Planning Officer: Mr S Davis

Planning Application Ref: Y/63/19/RES

Location: Bonhams Field, Main Road, Yapton, BN18 0DX

Description of works: **Approval of reserved matters following the grant of Y/1/17/OUT for 56no. dwellings with associated open space & creation of new access. This application affects the character & appearance of the Yapton (Main Road) Conservation Area & affects the setting of listed buildings**

scheme: Bonhams Field
Yapton
client: Seaward Properties Limited
drawing: Tree Reference Plan
date: August 2016
scale: 1:500@A1
dwg no: SEA20727-03A
drawn: RA checked: MW

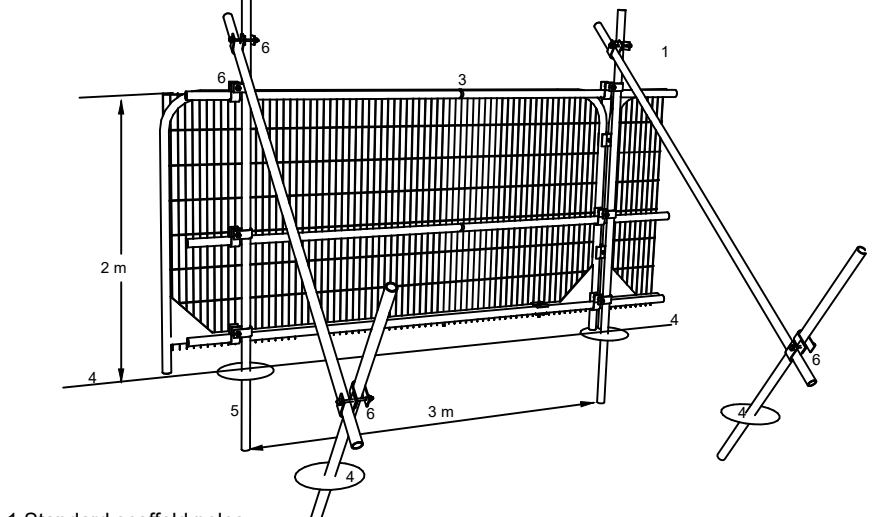
- Introduction of hard-surface parking bays within RPA and canopy spread of category A oak (T30), tree worthy of statutory protection.
 - Loss of north-south open space along east boundary of site which captured a substantial linear group of trees that contribute to the landscape.

- The current Arboricultural Impact Assessment & Method Statement and Tree Protection Plan clearly do not support this Reserved Matters layout which if ultimately approved would have to be updated to address the above areas of conflict and demonstrate how retained trees would be adequately protected.

- The applicants will need to employ the services of an Arboricultural Consultant to carry out a tree survey exercise and then prepare an up-to-date Arboricultural Impact Assessment (AIA) which must be inclusive of; a 'Tree Survey Schedule', a 'Root Protection Area (RPA) Schedule' and a 'Tree Constraints Plan' – with the trees accurately plotted on same.

- In the event that a RPA of any tree which is proposed for retention overlaps the development then BS5837:2012 requires that the Detailed Planning Application is accompanied by an Arboricultural Method Statement (AMS) and also most importantly a Tree Protection Plan – to both describe and illustrate the mitigation measures which are to be employed to ensure that the trees survive without detriment to their vigour and vitality and are given adequate protection both above and below ground.
